From: Stephen Harlow [REDACTED]
Sent: 13 November 2020 11:21
To: Planning <Planning@arun.gov.uk>; Andrew Wood <Andrew.Wood@arun.gov.uk>
Cc: nicola.harlow [REDACTED]
Subject: EP/124/20/HH

There will be a lot to get through with our observations and objections to planning application EP/124/20/HH (23 Upper Drive, East Preston) so there is no time like the present to make a start.

203075/ 07

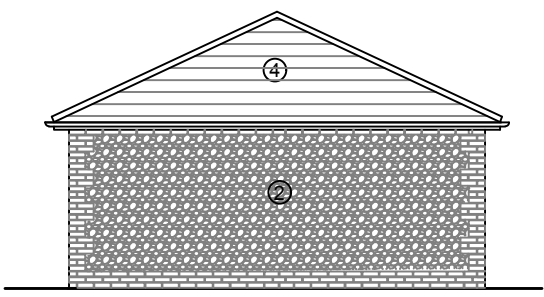
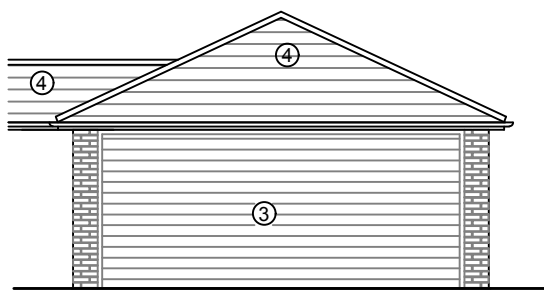
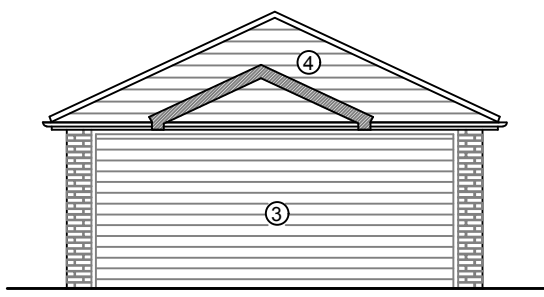
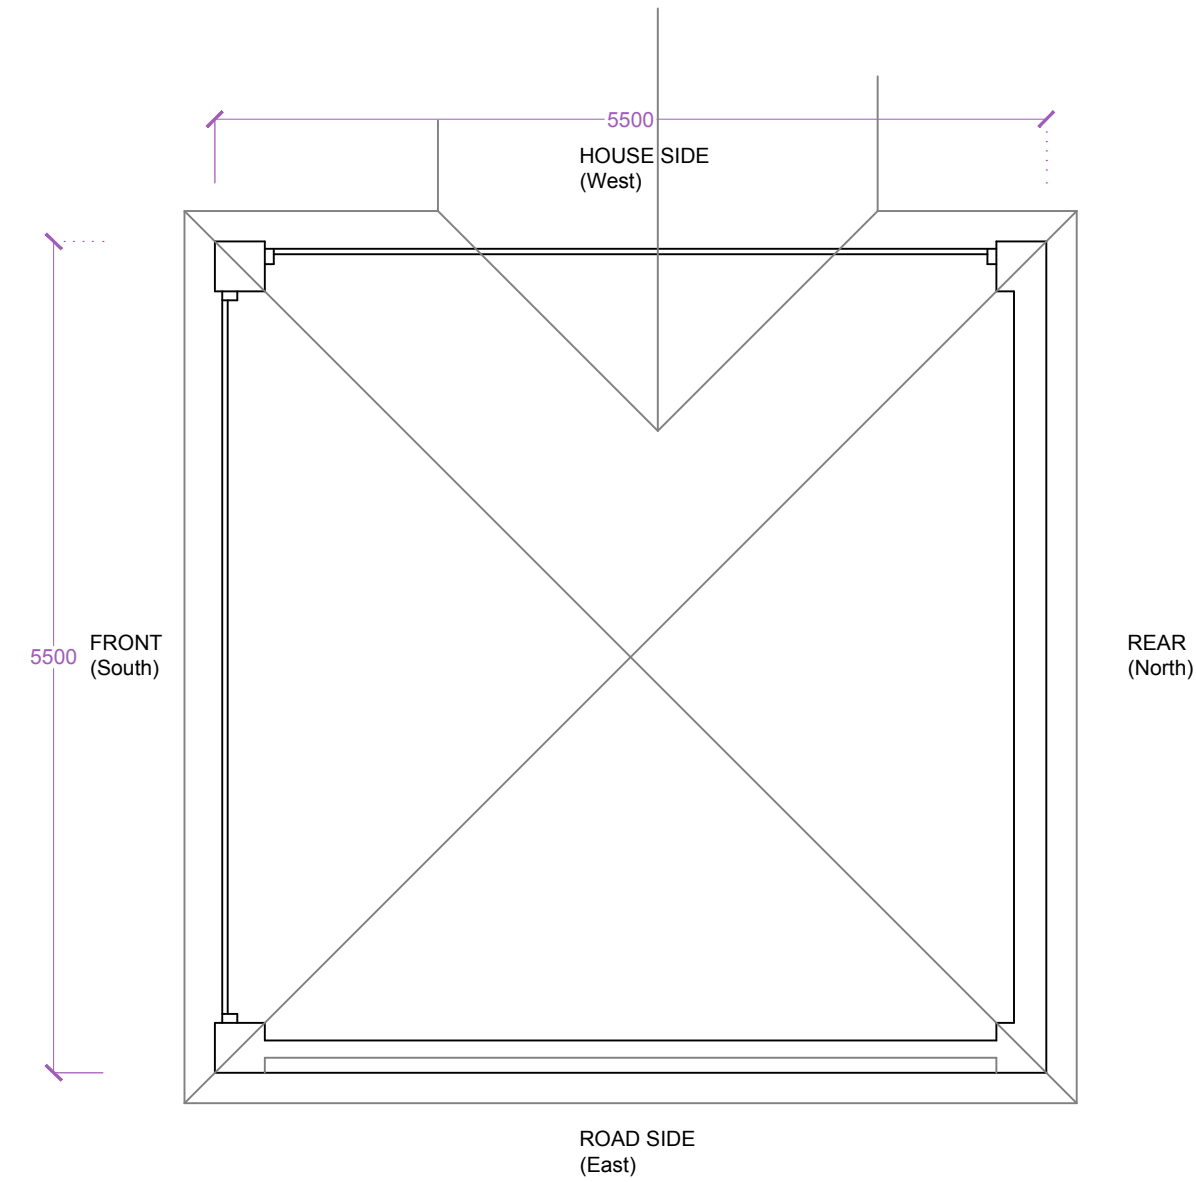
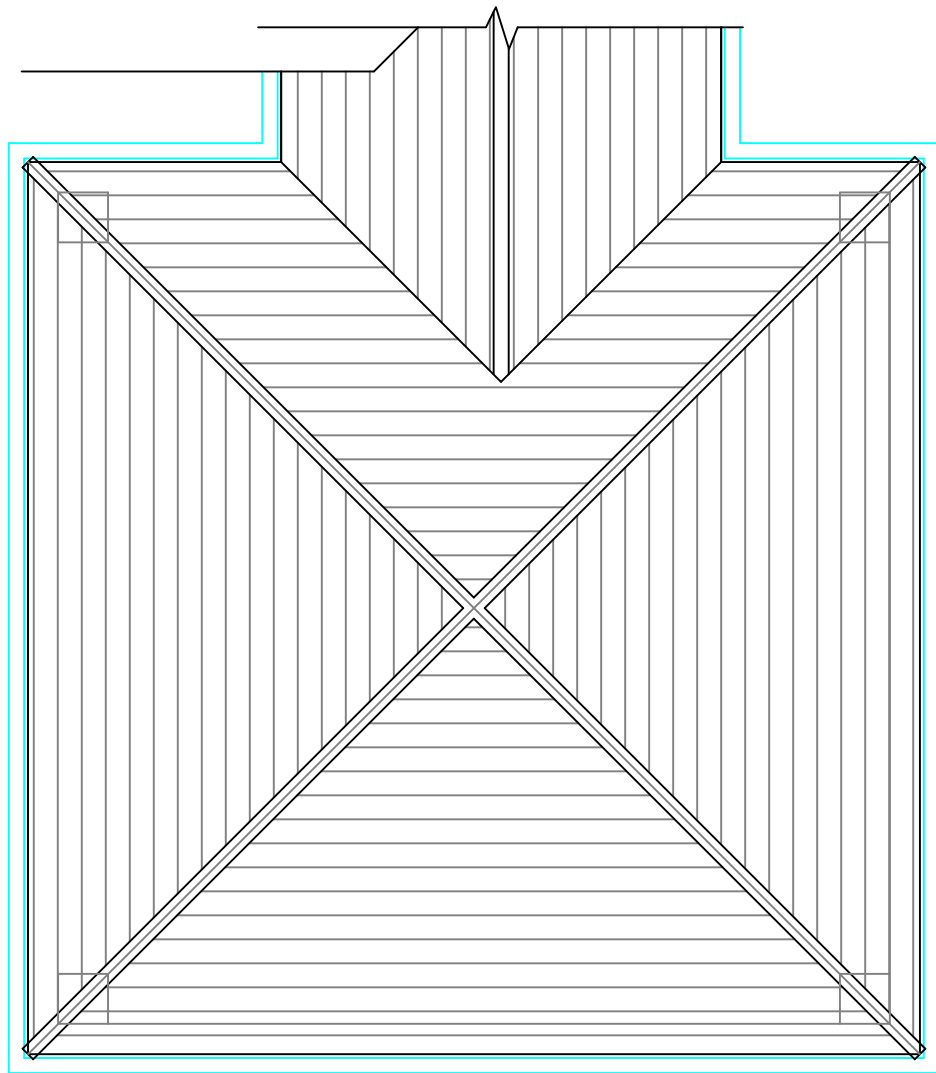
2. I object to the large (5.5m x 5.5m x 3.67m) structure in the front garden. These are the reasons:

2.2 Arun DC Design Guide says "Extensions should also preserve the amenity of the original and neighbouring properties in terms of privacy and overshadowing". The structure would degrade the light and amenity at Number 23 Little Dormers itself. The natural light to the reception room would be reduced and also affect the amenity for current and future residents.

2.3 As the owner of the adjacent property (number 25) I can report that the structure would be guilty of overshadowing and loss of amenity.

Light would be lost in my closest reception room. The structure would be 2.5m from the east facing window and extends 5m forward of my house.

Failing the usual 45 degree test, this structure should not be built.

2.4 The proposed structure is beyond the building line in this part of Upper Drive. It would be an over-bearing presence of the street scene - contrary to Arun Local Plan (2011-2031) Pages 159 -160: Policy D DM4. My opinion is that it would make an adverse contribution to the street scene and so would not meet the principle of the East Preston 2014-2019 Neighbourhood Submission plan (esp 4.10 and 4.16)
